CITY OF PORTLAND BUILDING PERMIT

Job ID: 2012-02-3381-CH OF USE

has permission to Change the Use from Karate Studio to Religious Assembly with interior alterations only provided that the person or persons, firm or corporation accepting this permit shall comply with all of the provisions of the Statues of Maine and of the Ordinances of the City of Portland regulating the construction, maintenance and use of the buildings and structures, and of the application on file in the department.

Conditions of Approval:

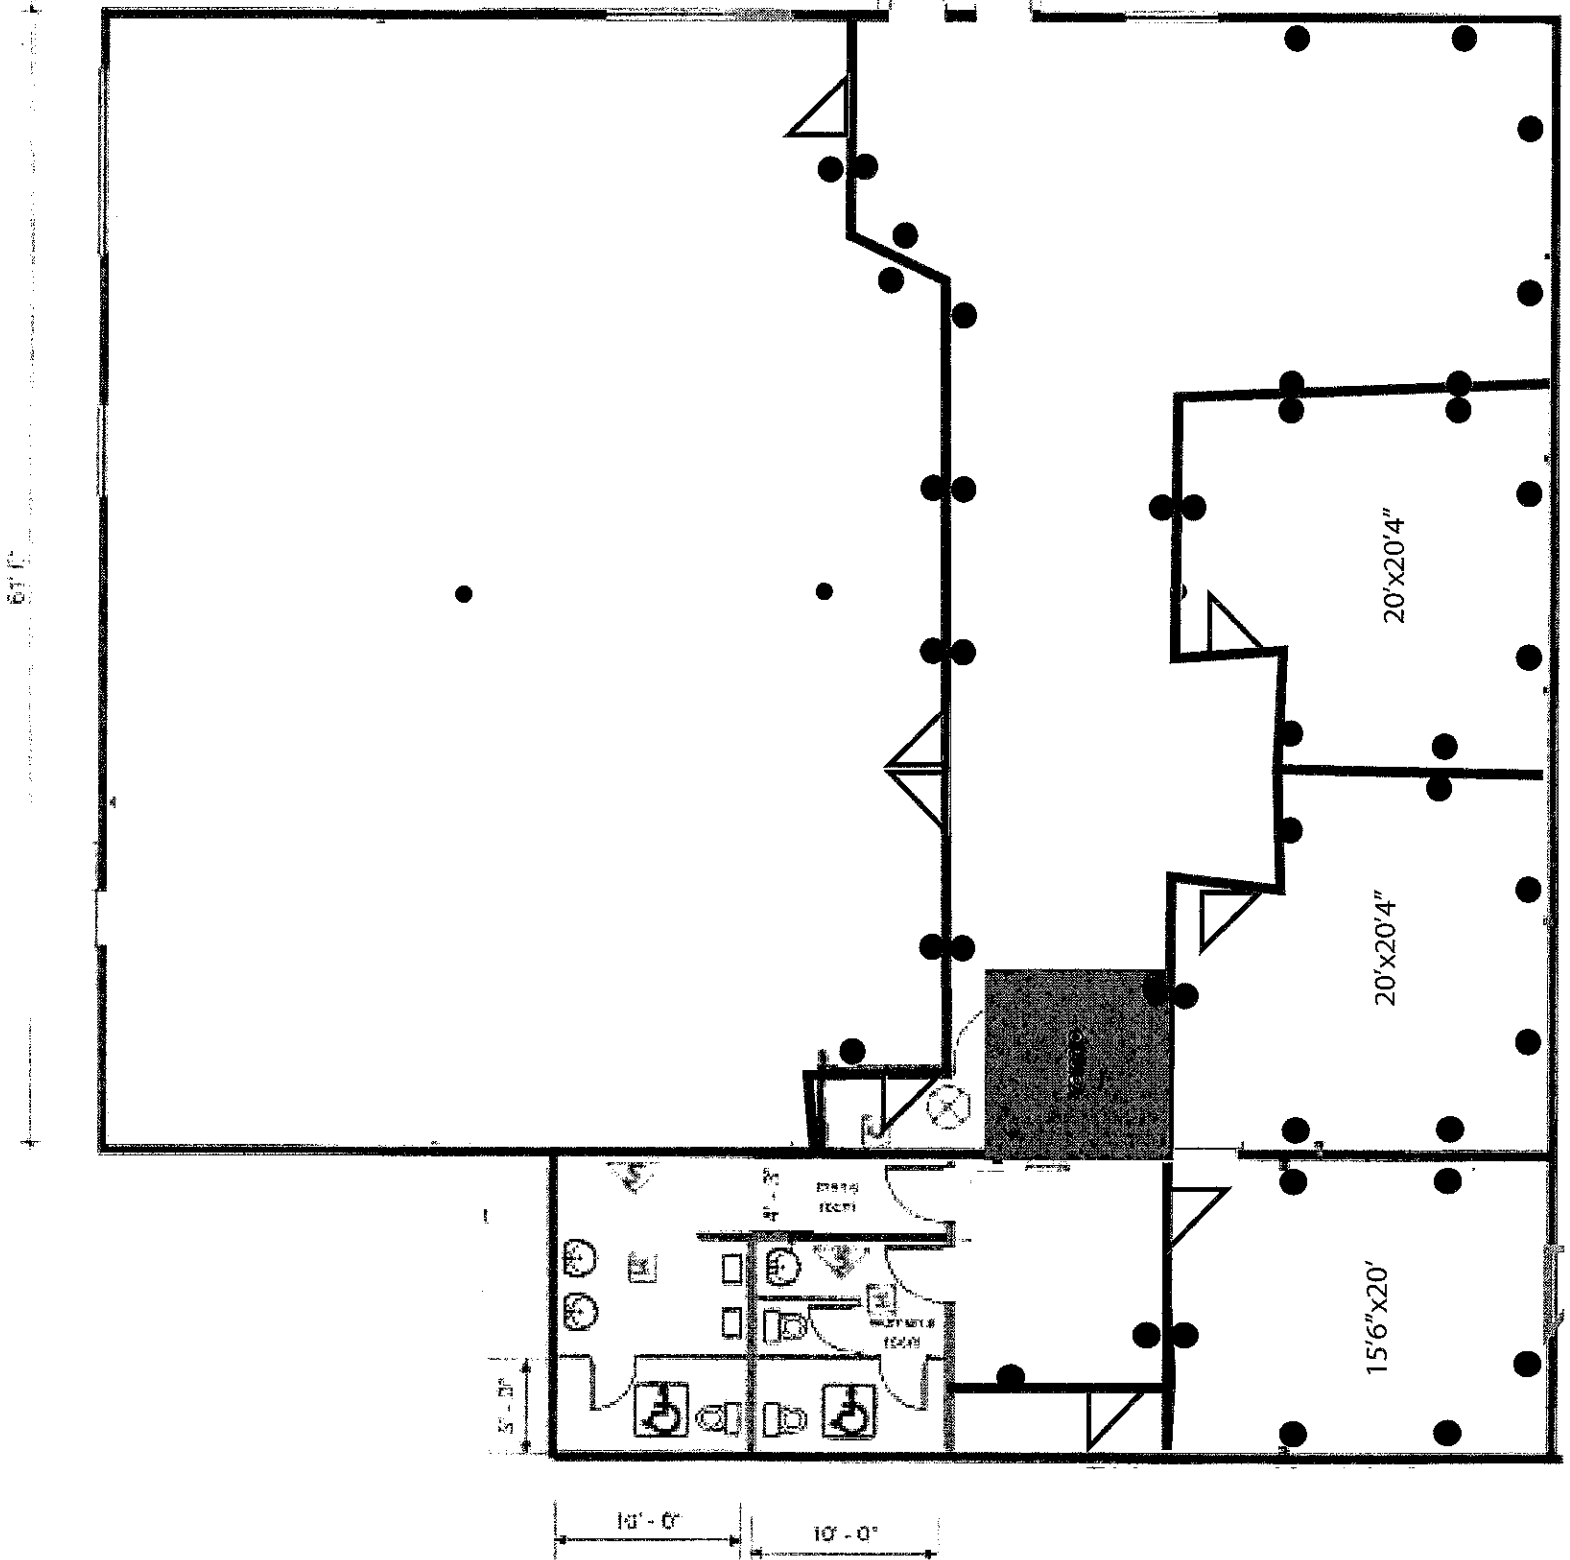
4. The second remote exit directly outside to grade from the auditorium is required per NFPA 101:7.5.1.3.2 and NFPA 101:12.3.6, and it shall be installed in accordance with NFPA 101:43.5.1.3.

10. Auditorium: 160 unsecured seating (15 net)(Must be posted with an approved seating chart)
11. Small classroom: 16 persons (20 net)
12. Large classrooms: 20 persons each (20 net)

5. This approval is contingent upon the addition of a 2nd means of egress from the congregation room. A separate application for amendment and an Administrative Authorization Application is required for review prior to construction of such. **THE CERTIFICATE OF OCCUPANCY WILL NOT BE ISSUED UNTIL COMPLIANCE IS SATISFIED.**

# DECK DETAILS

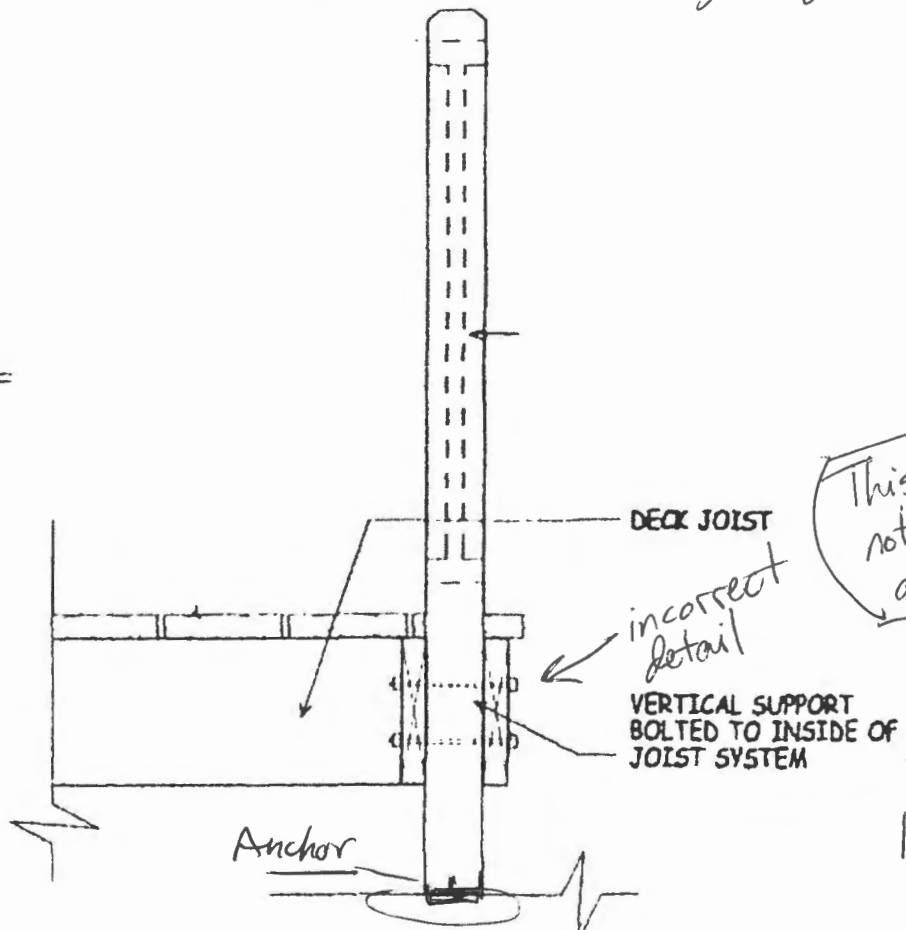
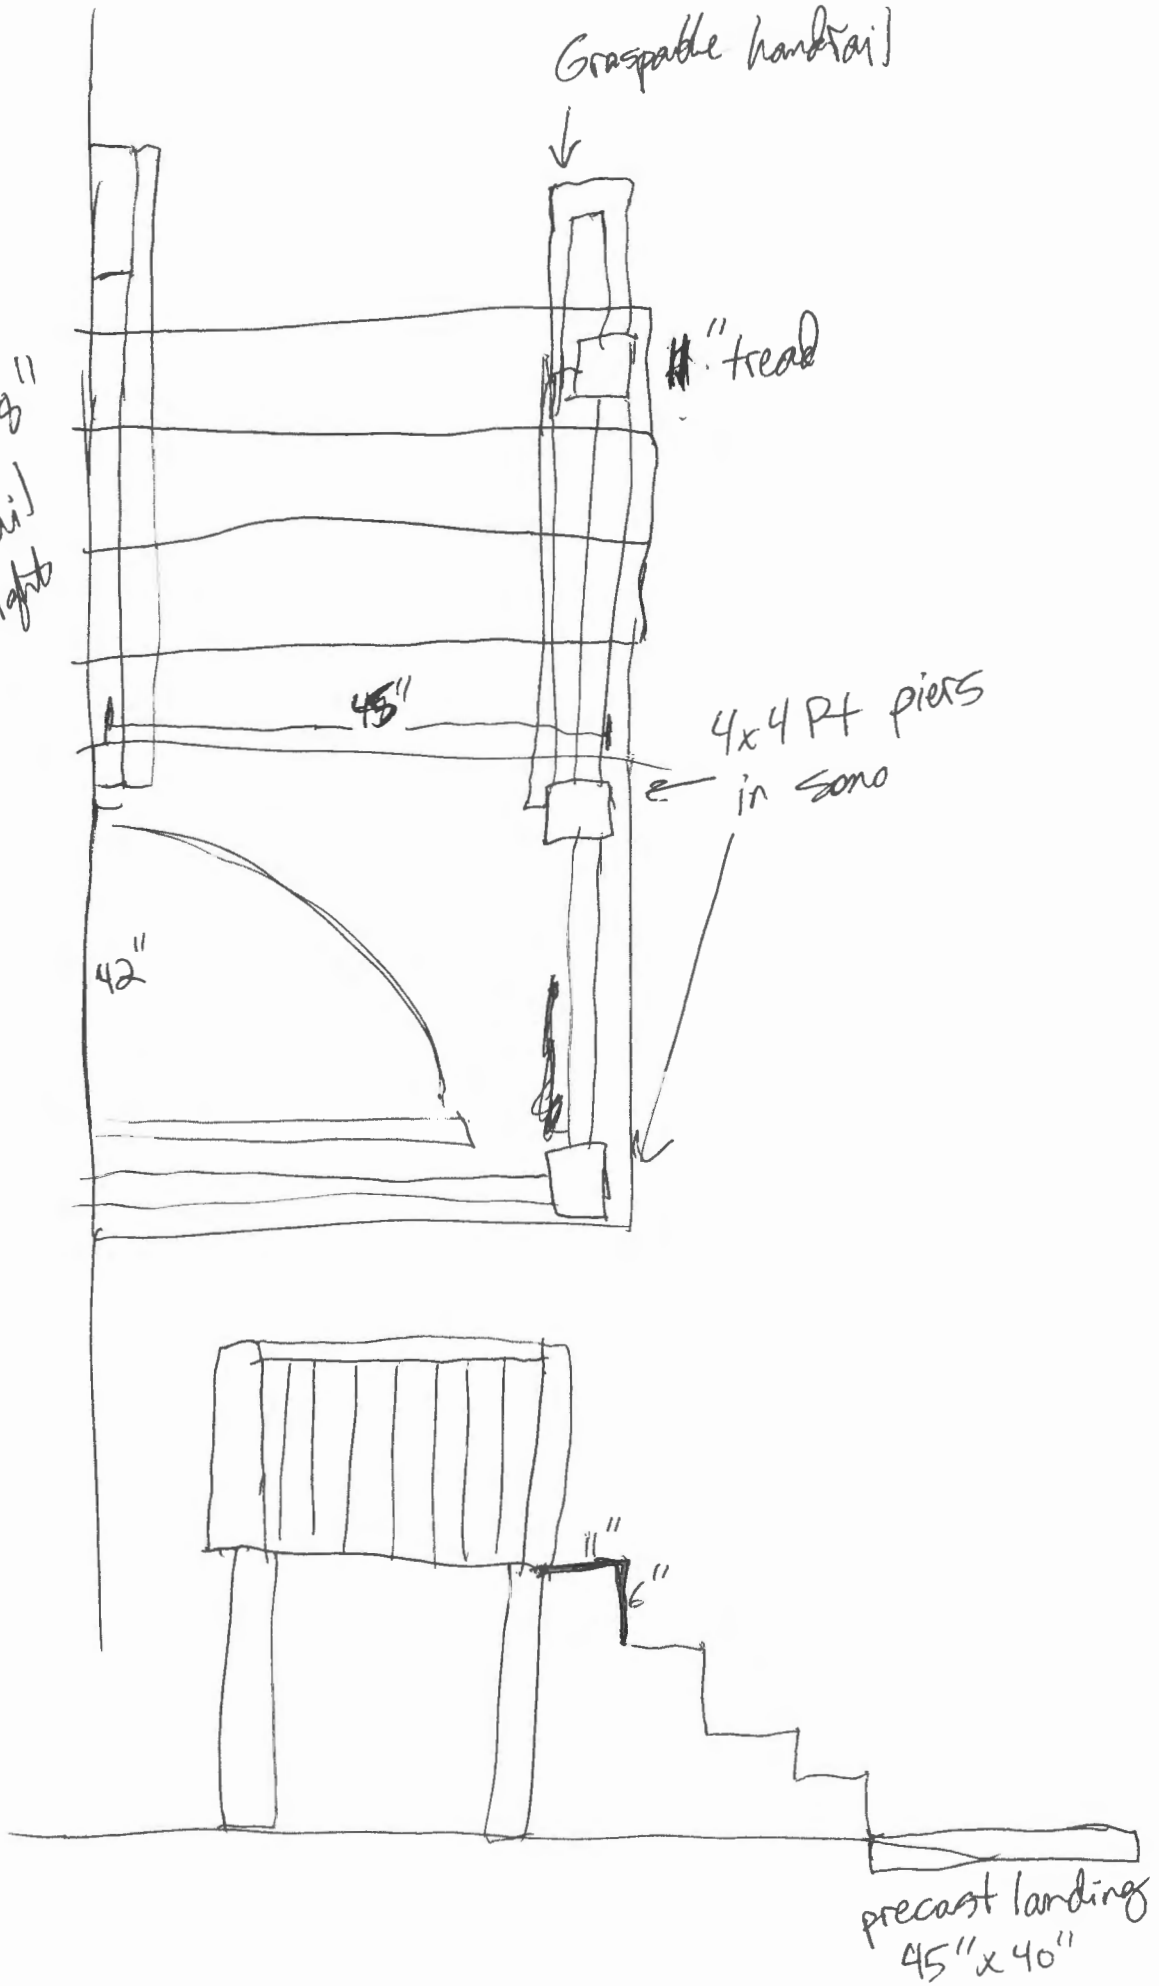
5. Stairs, ramps, landings, handrails and guards shall be in accordance with NFPA 101.
6. Doors serving rooms or areas with an occupant load of 50 or more shall swing in the direction of egress. Exit doors serving the auditorium shall have panic or fire exit hardware only. No other locks are permitted.
